EPC STORMWATER REVIEW COMMENTS
IN ORANGE BOXES WITH BLACK TEXT

FINAL SITE GRADING CONSTRUCTION PLANS
FOR

CREEKSIDE SOUTH AT LORSON RANCH FILING NO. 1

FINAL GRADING / EROSION CONTROL PLANS

**POND J
 POND J OUTFALL AND
 TRICKLE CHANNEL**

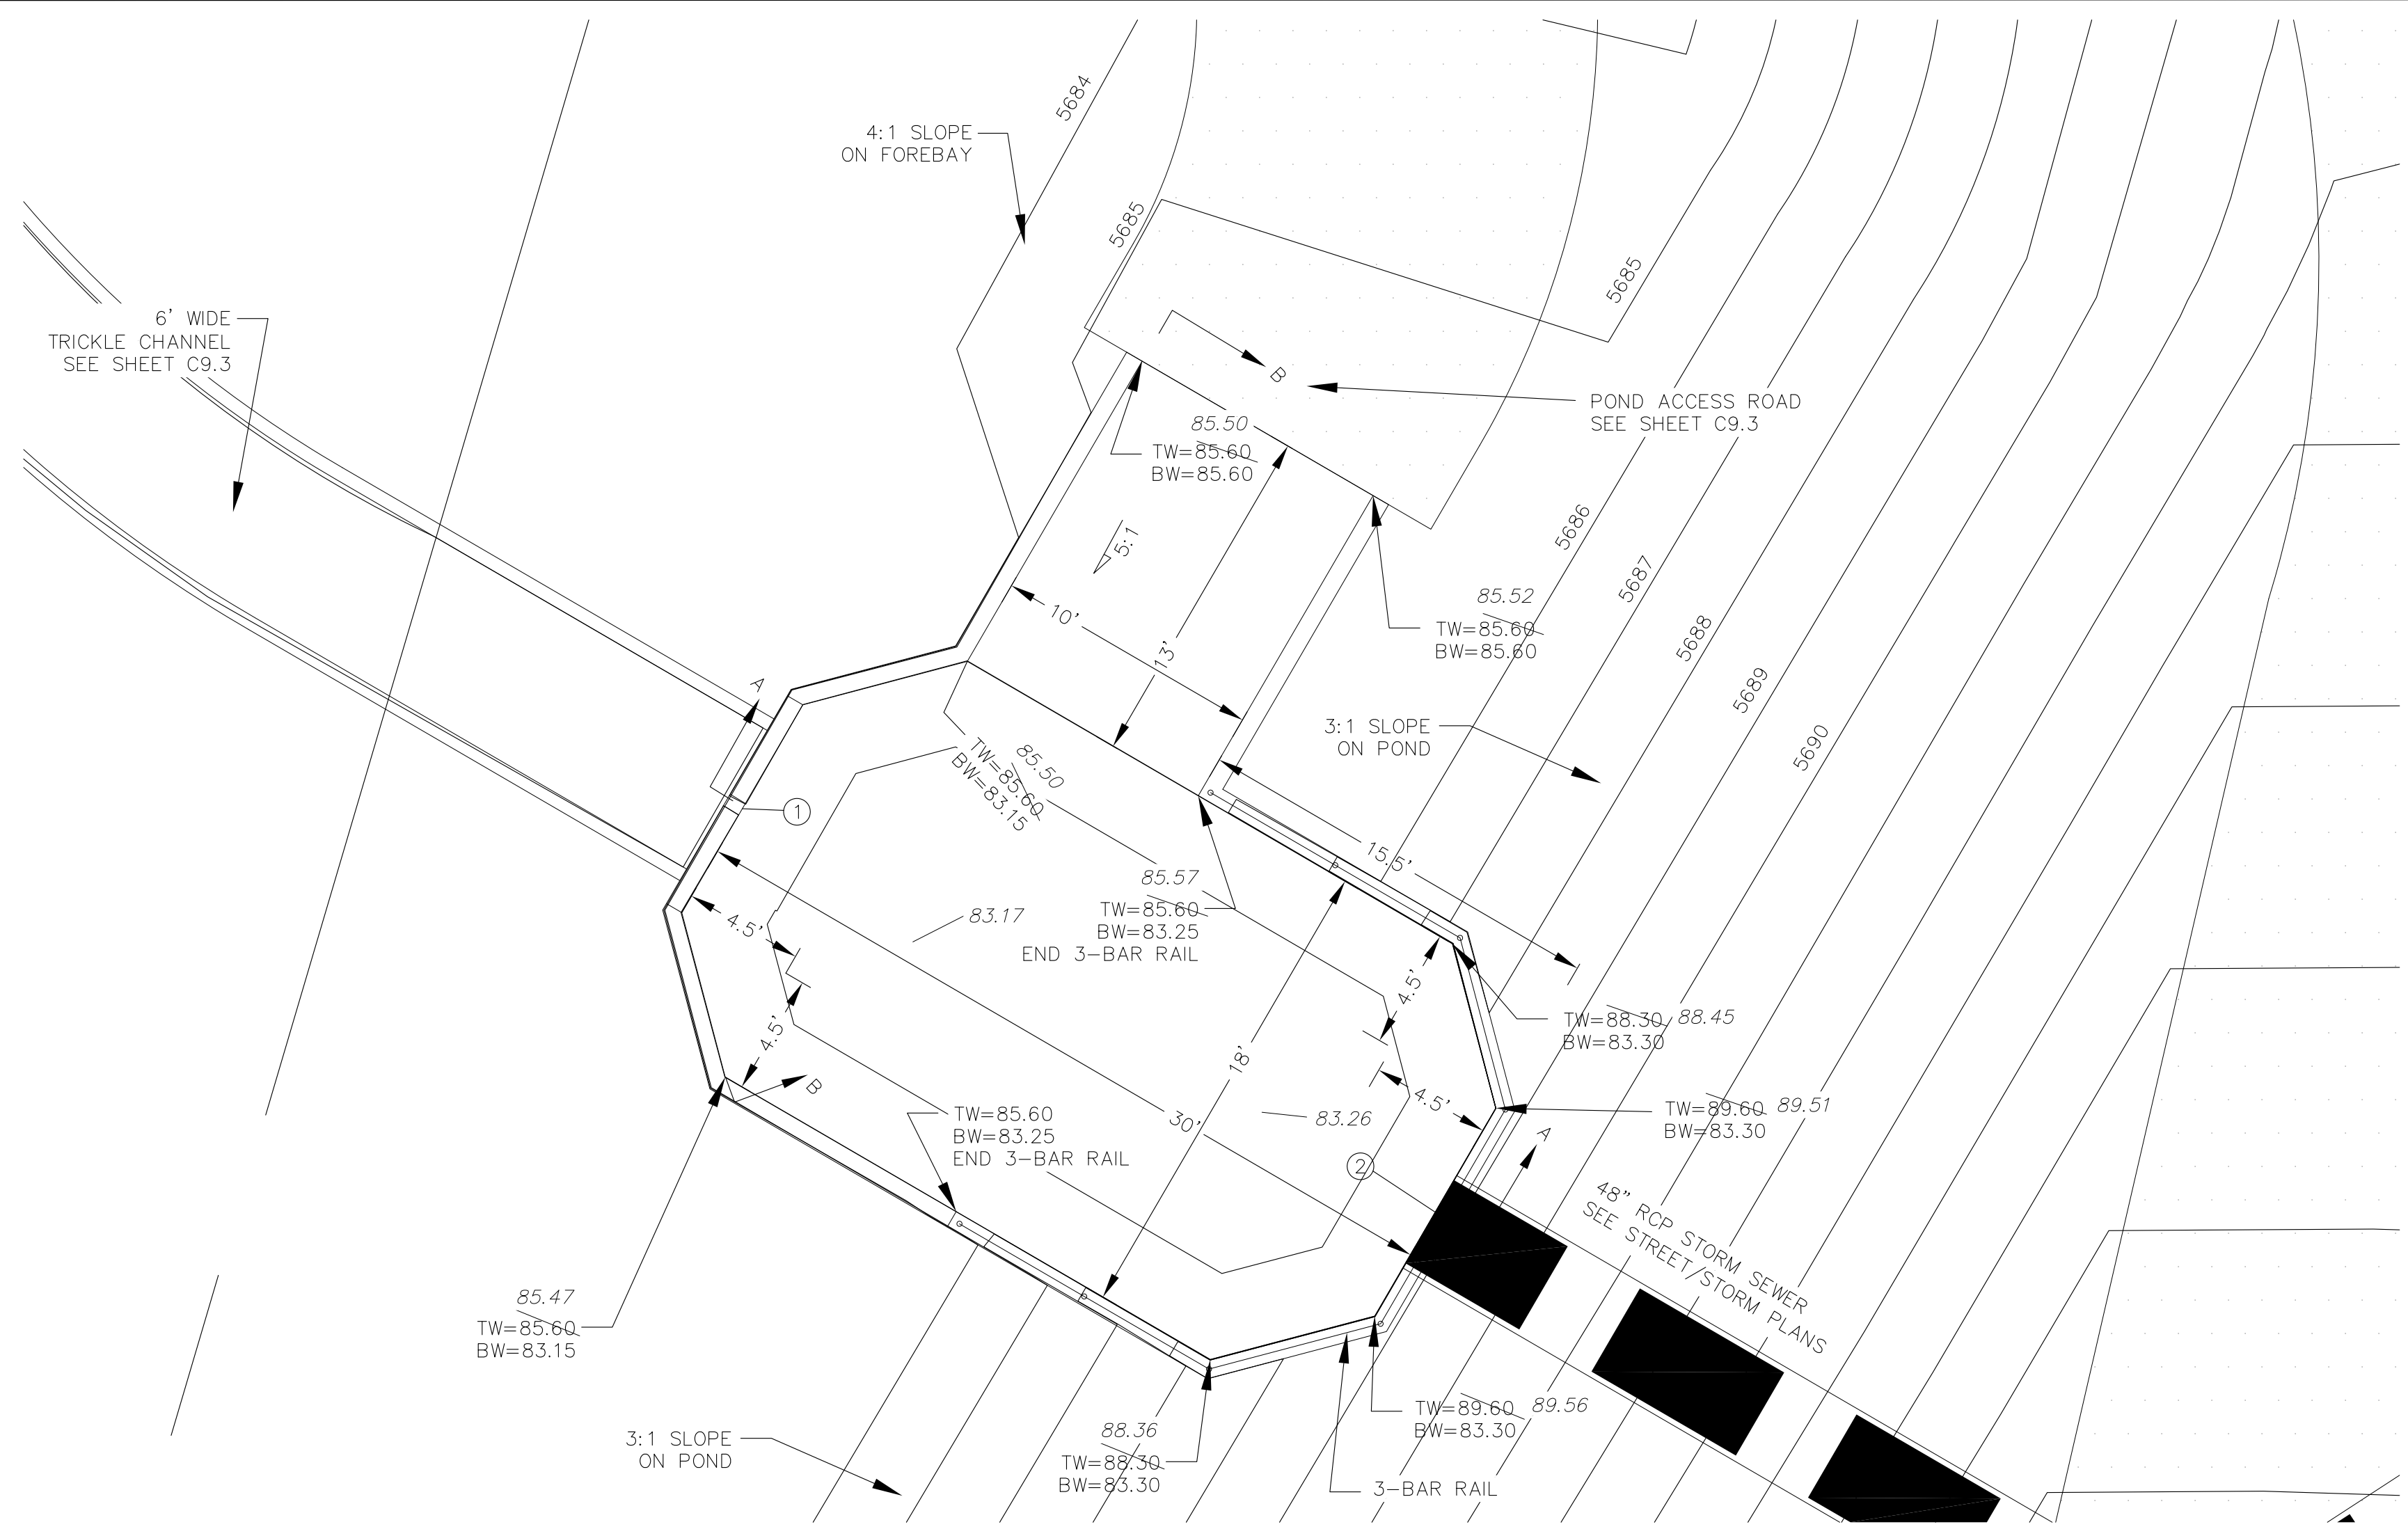
Provide a note detailing soil rip rap: will it be mixed or layered? What percentage of soil vs rip rap?

Show and label limits of Tract that is to be used as pond access easement for EPC inspections
